**DEVELOPED DRAINAGE PRAIRIE RIDGE EL PASO COUNTY, COLORADO**

Project Number: 07051  
 Sheet: 2 of 2

**NOTE:**  
ALL DRIVEWAY CULVERTS ALONG  
BROWN ROAD ARE TO BE 18" RCP AT A  
MIN SLOPE OF 2%

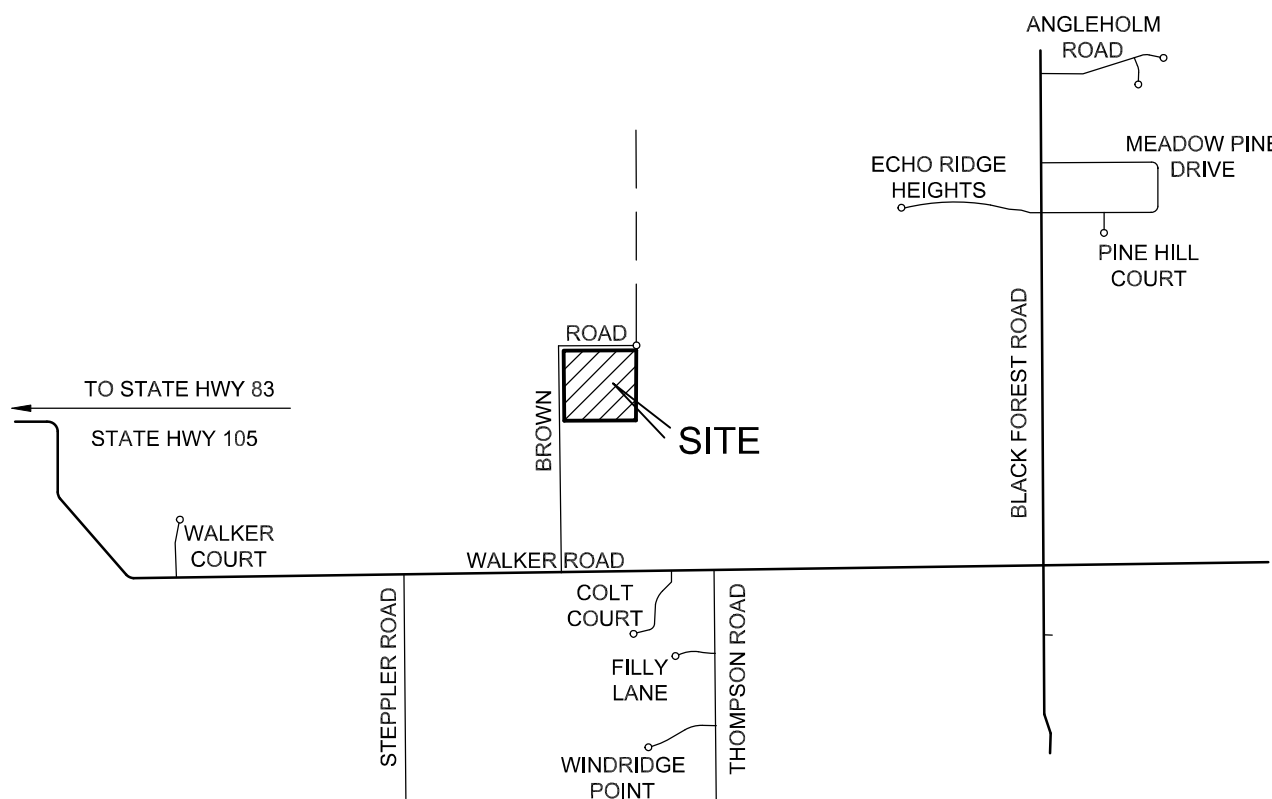
Please also provide a summary table of the flows at the design points.

The narrative indicates a 42" RCP culvert to replace the existing culvert. Revise accordingly.
